**Consultation Response from KC,
Trees**

2025/91880 14, Manor Road, Farnley Tyas, Huddersfield, HD4 6UL

Erection of single storey rear extension and associated alterations (within a Conservation Area)

Date Responded: 30/07/2025

Appendix 6: Tree Impacts Plan

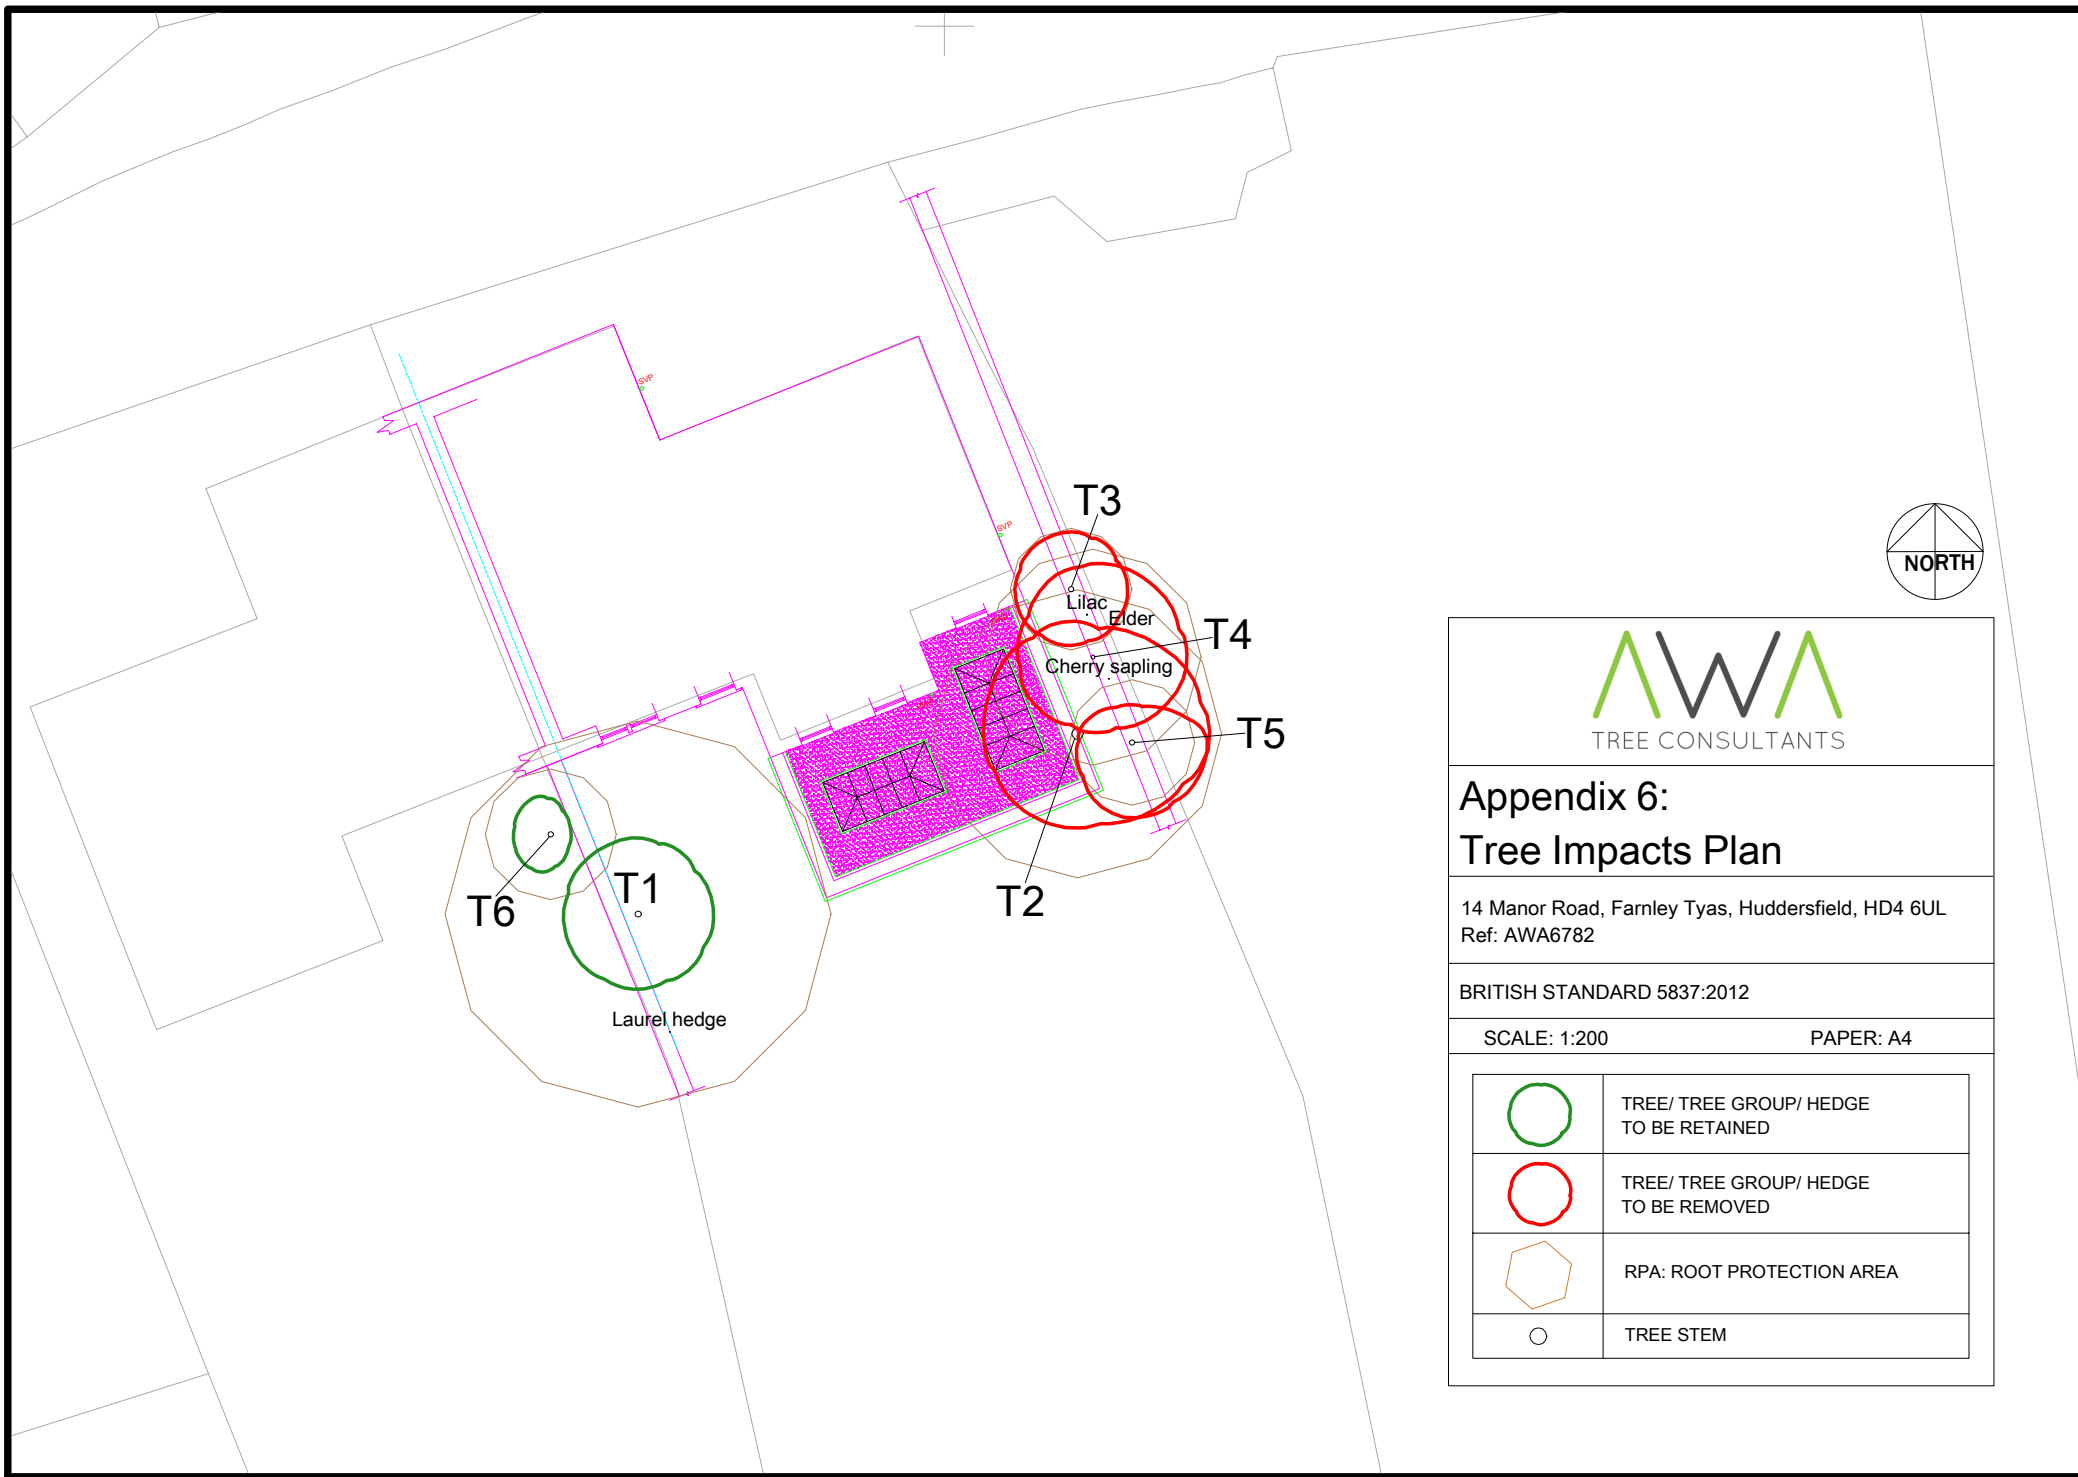
The proposals will impact trees on the boundary of the site. Therefore, a tree survey and AIA has been submitted in support of the application ref AWA6782, dated 1st July 2025. The tree survey records all items as Category C, low arboricultural value. Four trees would be required to be removed to facilitate the development. **There are no objections from an arboricultural perspective, with conditioned replanting:**

That within two years, the felled tree(s) be replaced by 2x Scots Pine and 1X Cherry 1.5-2m in height when planted, located within the site and sourced and planted in accordance with BS8545.
